CWWTPR DCO Examination**Submission by Save Honey Hill Group****SHH 34 Response to the Applicant's Responses to Written Representations AW 8.13 [REP2-038]****18 December 2023**

SHH's response refers to Table 2-11 and quotes the paragraph numbers in the SHH WR as used in REP2-038

CWWTPR DCO Examination**Submission by Save Honey Hill Group****SHH 33 Response to the SCDC and Cambridge City Council Response to SHH Written Representations (REP2-051 and REP2-049)****18 December 2023**

**Viewpoint 22: Residents of Poplar Hall and Poplar Hall Farmhouse looking south, residents of Red House Close looking north and users of Footpath Fen Ditton 85/6**

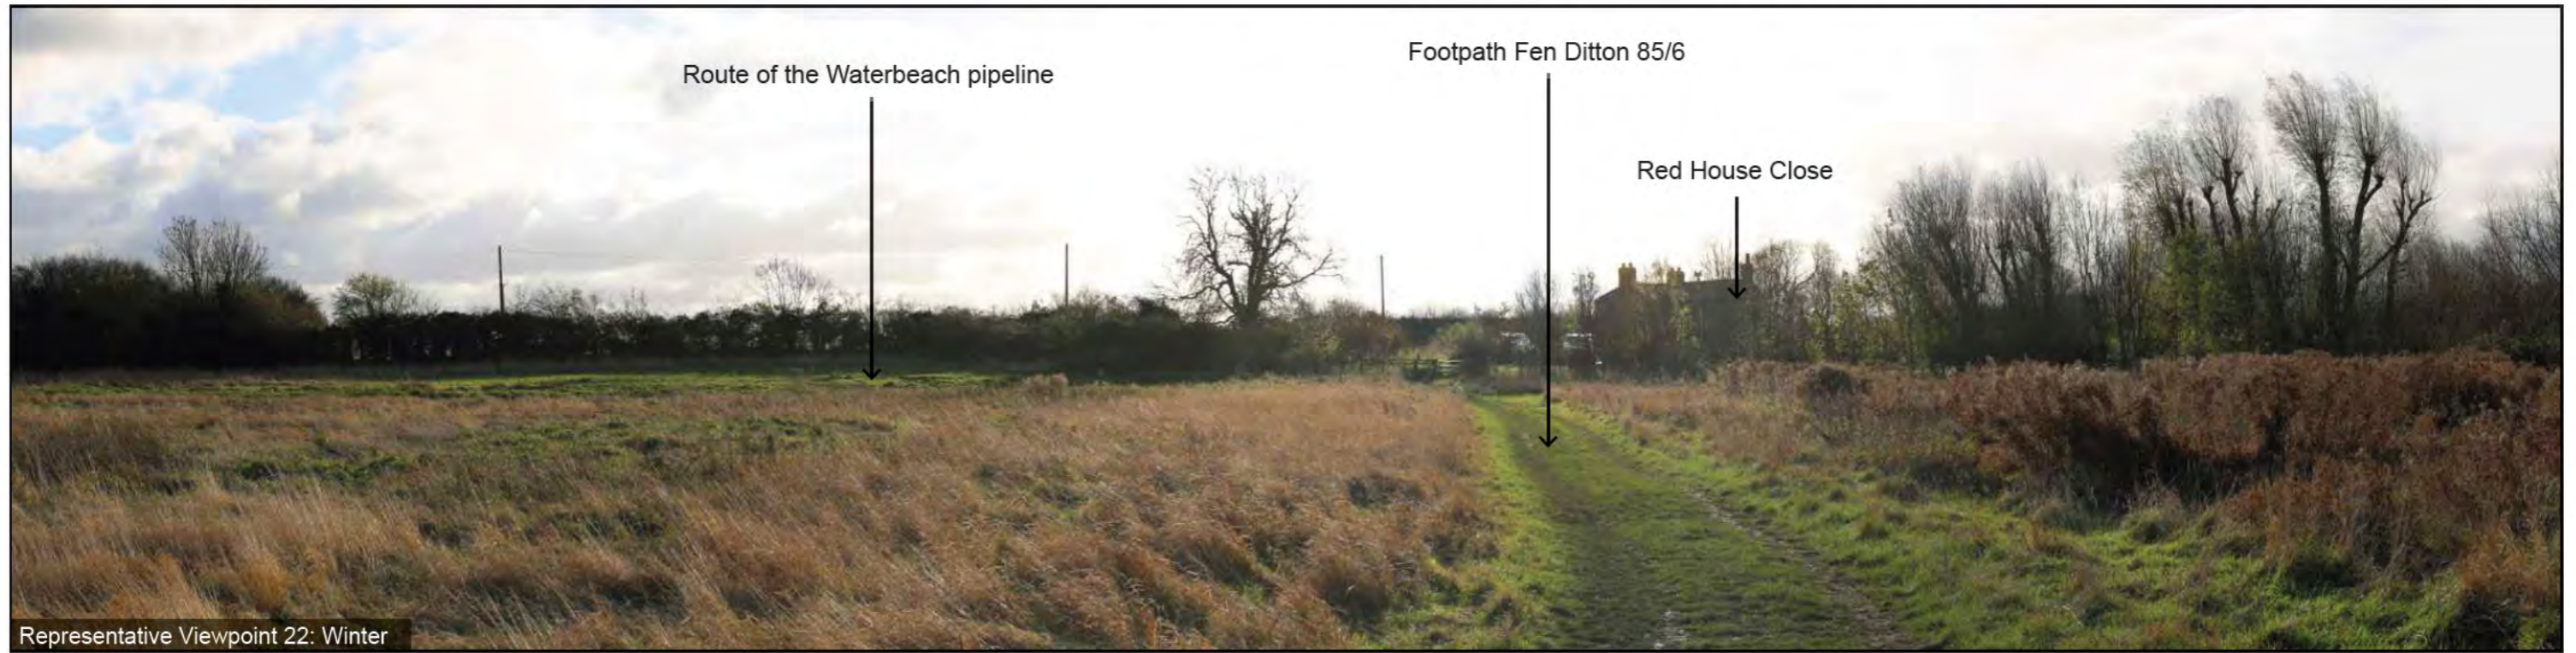
8.2.8	Viewpoints	<p>SHH notes the Applicant's guidance about viewing photomontages and trusts that the ExA and other parties will be provided with prints at A1 size to enable this to happen.</p> <p>SHH notes the Applicant's comments on VP 23. In the case of Footpath 85/6, SHH raises concerns here about the sustainability of the mitigation proposed to cover the roof of the discharge outfall from view. The roof is specified as being at or around ground level. In reality, the dDCO has been amended to allow that structure to deviate to be up to 500mm higher than has been designed and assessed. In the context of the low riverbank, this is a potentially substantial upper deviation. Whether it remains practicable to cover the main structure away from the river bank with soil and grass remains to be demonstrated. This will have an adverse significant impact on visual amenity along this stretch of vegetated river bank, particularly when viewed northwards towards the woodland area and Baist Bite Lock.</p> <p>VP25 SHH maintains the position that this viewpoint should be awarded a high sensitivity rating.</p> <p>VP5 The Applicant in its Response refers to Newmarket Road, however this viewpoint is intended and shown in Fig 15.1 (AS-048) as being on High Ditch Road looking NW towards the PD. The conclusions drawn in SHH 04 (REP-171) relating to VP5, VP7, and VP9 stand.</p> <p>VP 28 SHH notes and accepts the Applicant's comments.</p>	<p>SHH REP-171</p> <p>AW 5.3.15, (AS-048) AW 5.2.15, (AS-034)</p>
